18 February 2022

Joe Fittell
Team Leader - Resource Assessments
Department of Planning, Industry and Environment (DPIE)

Glendell Continued Operations Project (GCOP) – Draft Conditions of Consent (Noise)

Figure 11: Noise Receiver Areas

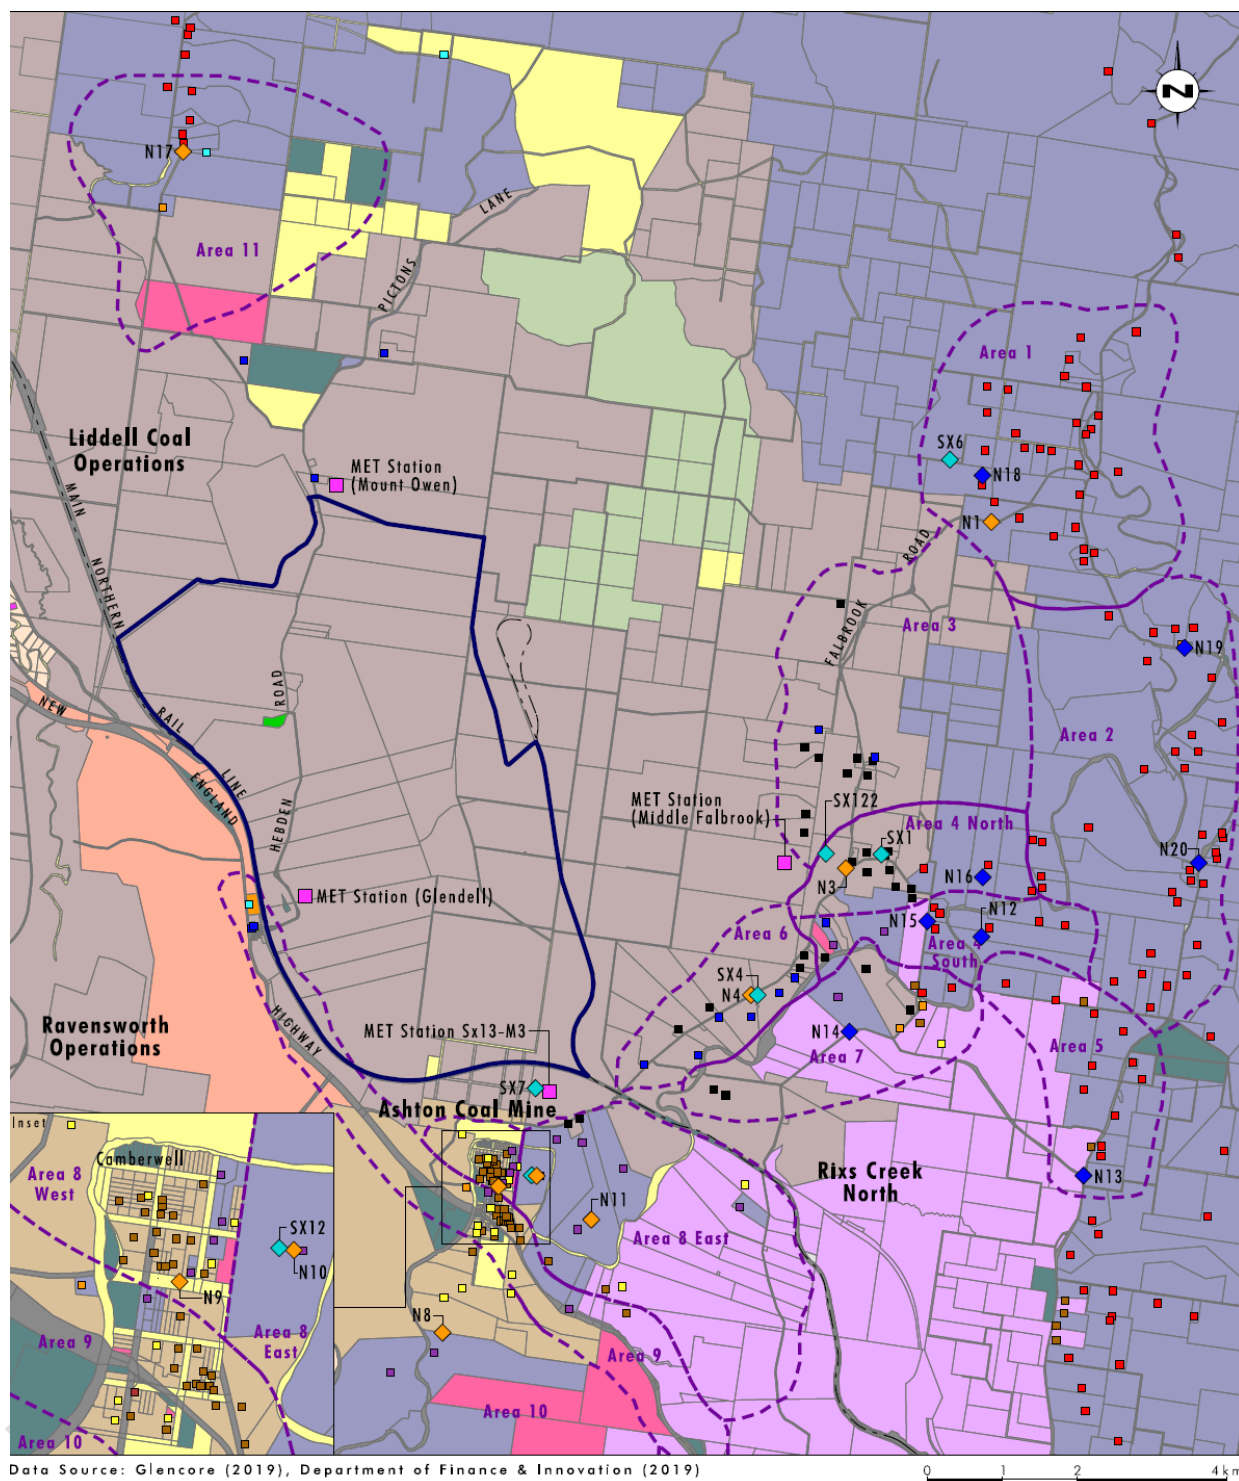
In conclusion, Glencore is seeking a consistent application of the relevant NSW Government Policy in relation to sleep disturbance criteria. The adoption of the 52 dB $L_{A Max}$ sleep disturbance noise limit set out in Table D.1 in the NIA as the noise criteria for the Project (as originally identified in the 10 June 2020 EPA letter) is consistent with both the NPfl and recent approvals granted by the IPC and also aligns with relevant international guidance. The below proposed revised draft development noise condition B1 and B2 reflects this approach:

- B1 The Applicant must ensure that the noise generated by the development does not exceed the criteria in **Table 1**.

Noise Assessment Location ^a	Day	Evening	Night	Night
	L_{Aeq} (15 min)	L_{Aeq} (15 min)	L_{Aeq} (15 min)	$L_{A Max}$
Residences on Privately-Owned Land				
Areas 1, 2, 4, 5, 7 and 11	40	35	35	52

Area 8	40	40	38	52
Area 9	40	40	38	52
Area 10	40	38	37	52
Other privately-owned residences	40	35	35	52

^a The Noise Assessment Locations referred to in Table 1, are shown in Appendix 3.
